**Consultation Response from KC,
Trees**

2024/93474 35, St John's Rd, Birkby, Huddersfield, HD1 5DX

Change of use from vacant industrial unit to 21 flats / maisonettes including partial demolition and new build

Date Responded: 07/04/2025

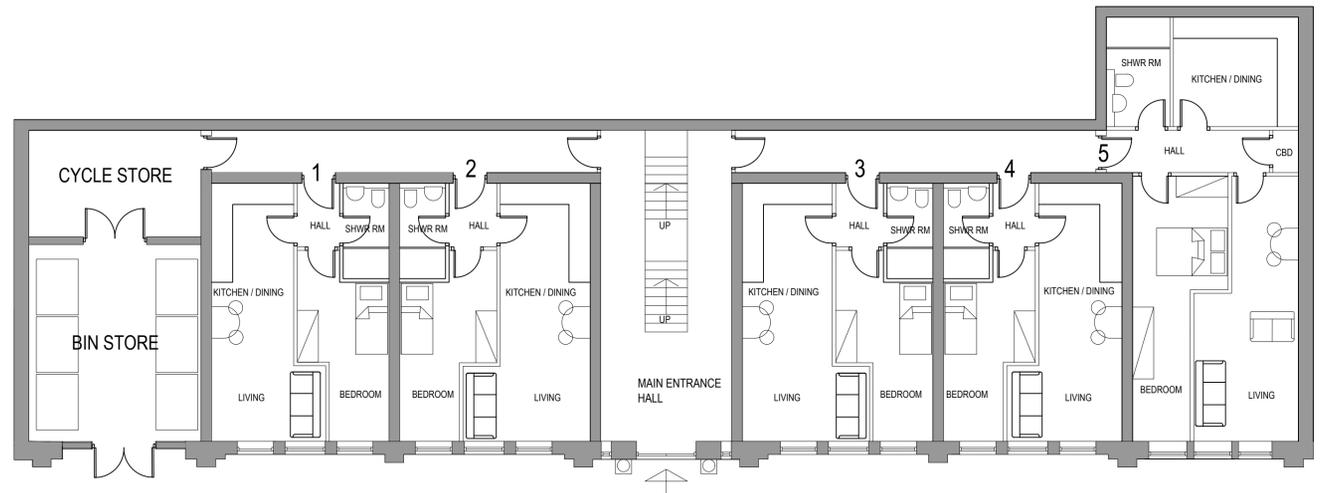
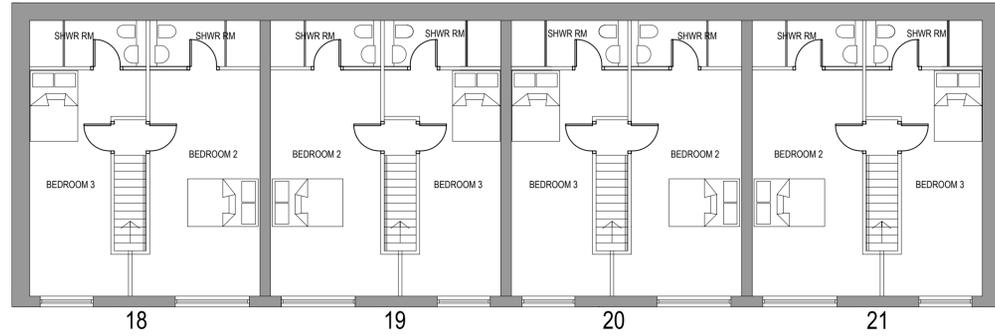
Whilst there are no protected trees on this site there may be significant impact on the trees to the rear of the proposed development. Some of the trees look to be mature and as a whole form a small woodland between Clare Hill and St John's Road.

An Arboricultural Impact Assessment would be required which overlays the proposed layout so that the true impact on the adjacent trees can be quantified.

There is a holding objection until the requested information is submitted because it is currently impossible to determine the true impact.
